Our Ref: 11386-145-200929-OCC Response
Your Ref: 20/01830/F

Date: 25 September 2020

RE: Proposed Roundabout Access to Graven Hill and Wretchwick Green, London Road, Bicester – Response to OCC Consultation

Project	Title	Client
GRAVEN HILL	A41 PIONEER ROAD ROUNDABOUT GENERAL ARRANGEMENT	 Graven Hill Village Development Company Limited

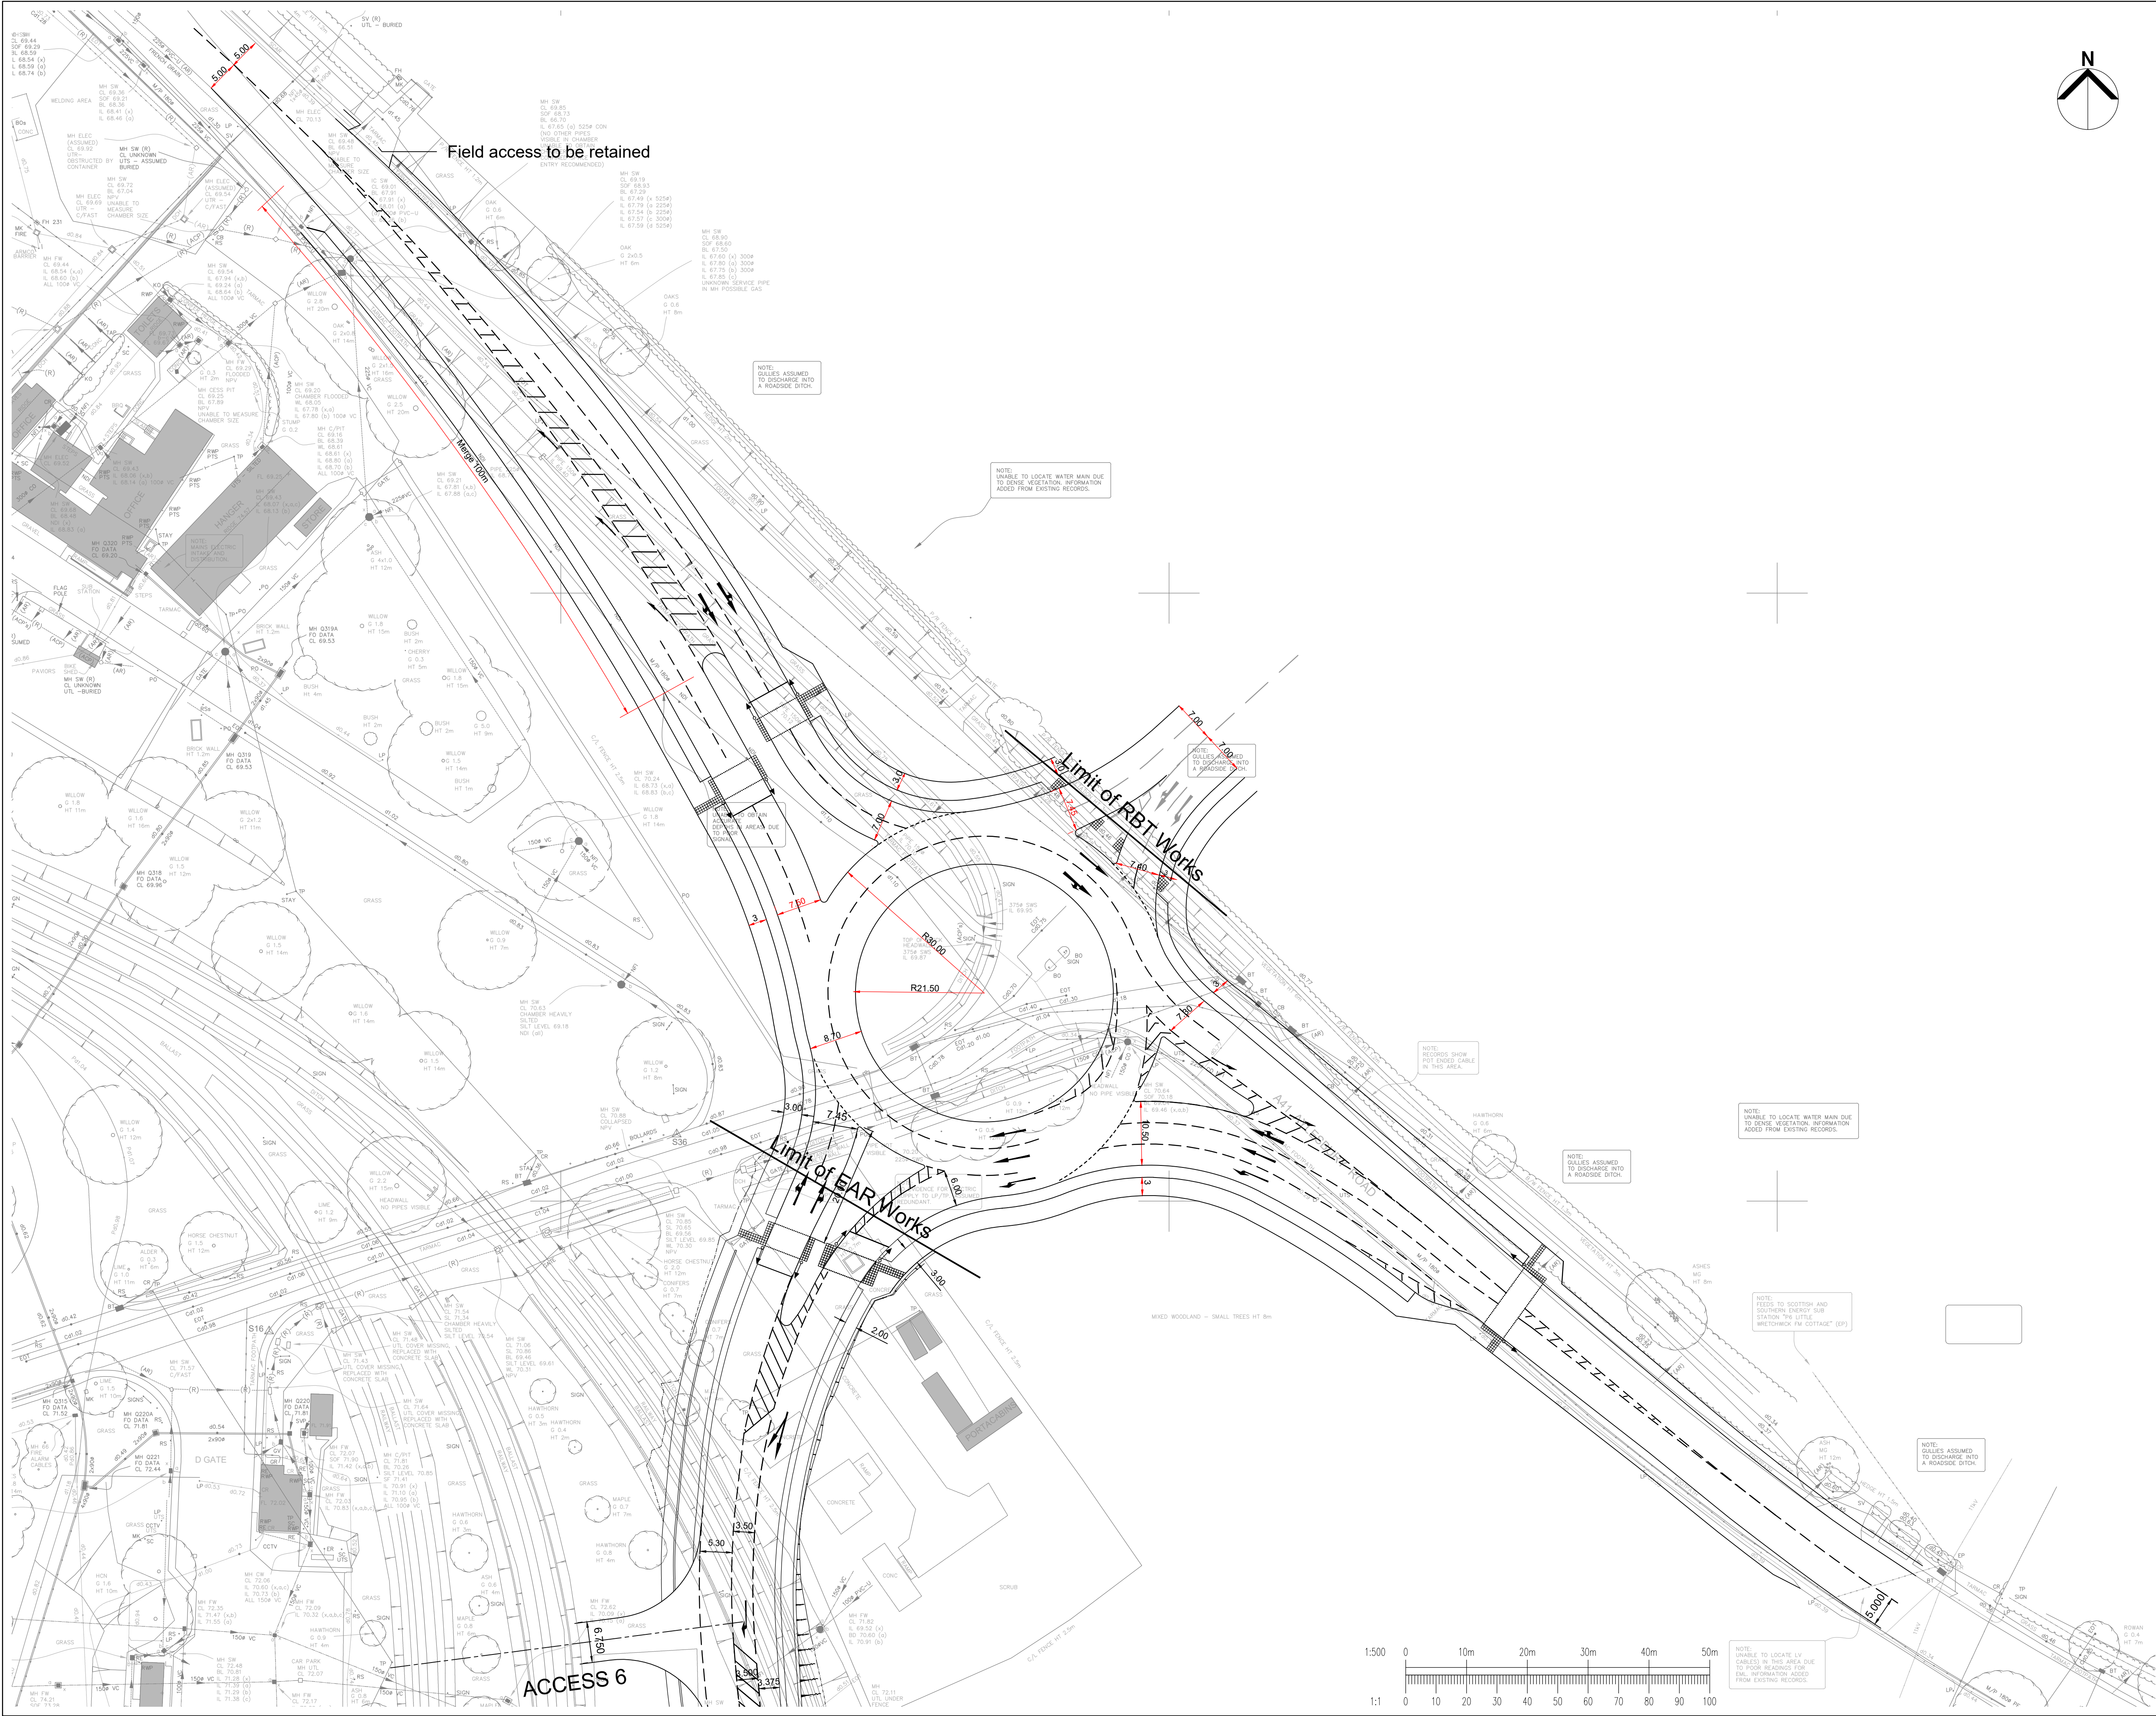
- Shared use pedestrian / cycle facilities around the roundabout should confirm to LTN 1/20 and therefore required to be segregated
- The signalised crossings should be straight across rather than staggered to minimise delay to pedestrians and cyclists

Following the comments received from OCC, the roundabout design has been reviewed and amended as shown on Drawing 11386-A41-03-001 A02 appended to this letter. The amendments made to the roundabout design are detailed as follows:

- Segregated pedestrian and cycle facilities are provided on the western arm of the roundabout, on both the Wretchwick Green and Graven Hill sides of the A41 London Road. The segregated pedestrian and cycles facilities connect with pedestrian and cycle proposals for the Graven Hill Employment Access Road. On the southern side of the A41 London Road the segregation continues west until it ties with the existing infrastructure provided on the A41 London Road
- Segregated pedestrian and cycle provision is now provided on the western arm. A staggered pedestrian crossing and straight across cycle crossing are now included on the western arm of the proposed roundabout. Further consideration on staging / timings for the traffic signals would need to be given at the detailed design stage once the planning application is approved
